Arun District Council
Arun Civic Centre
Maltravers Road
Littlehampton
West Sussex BN17 5LF
Planning & Building Control General Enquiries
Tel: (01903) 737756 Fax: (01903) 730442
Dx: 57406 Littlehampton
Minicom: 01903 732765
e-mail: planning@arun.gov.uk
website: www.arun.gov.uk/planning

Application No: BR/190/20/OUT
Site Address: 26 Burnham Avenue Bognor Regis PO21 2JU
Description of works: Outline application with all matters reserved for up to 10 No. new dwellings with associated services, landscaping, car parking & amenity (resubmission following BR/49/19/OUT).

Thank you for your internet representation made on 17th October 2020 which has been recorded as an objection with the comments as follows:

SITE PLAN (PROPOSED) 1:200

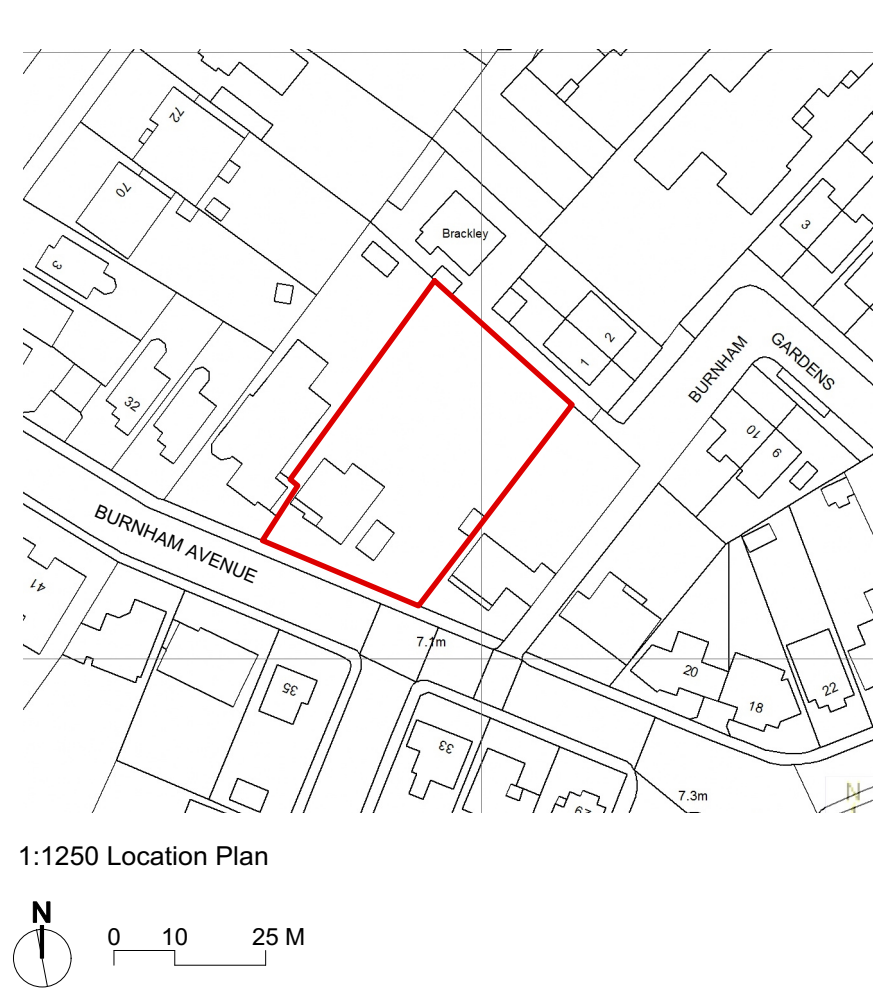
While there is a parking provision for the flats it is not adequate. Most two adult households have two cars, therefore, it is safe to assume that there will probably be two or more cars for each flat. If more than two people live in any one flat this will be more. Several households in the vicinity have three or more vehicles. Where will visitors park?

This will have a negative impact on the on street parking, particularly as the plans show there will be two

entrances to the site, one for the flats and one for the house, this will in turn take away several street parking spaces.

STREETSCAPE - SOUTH ELEVATION (PROPOSED) 1:100

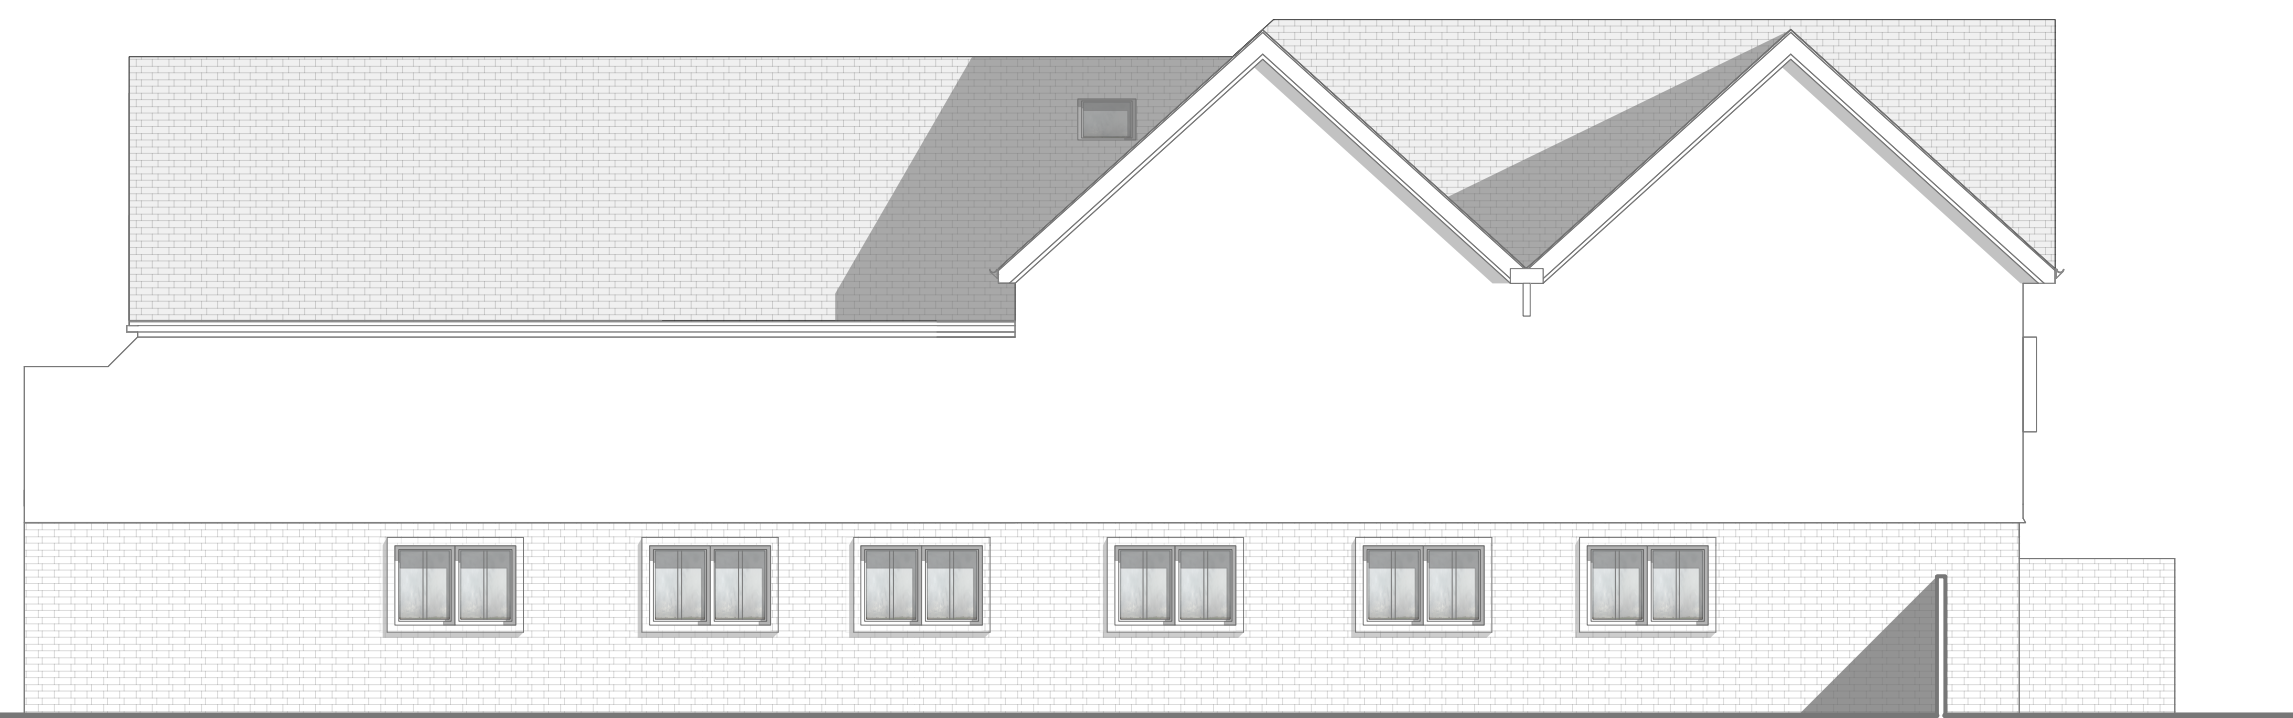
While I understand that the building will observe the existing building line and ridge height why do the flats have to be three stories high? This in my view is out of character with existing housing and could lead to some houses being overlooked. Just look at Deal House in Sturgess Road, there is no way that should be allowed to happen again. It's a monstrous eyesore. Roof heights and ridge lines can very easily creep upwards and it's easier to ask forgiveness (retrospective planning approval) than permission (advance planning permission).
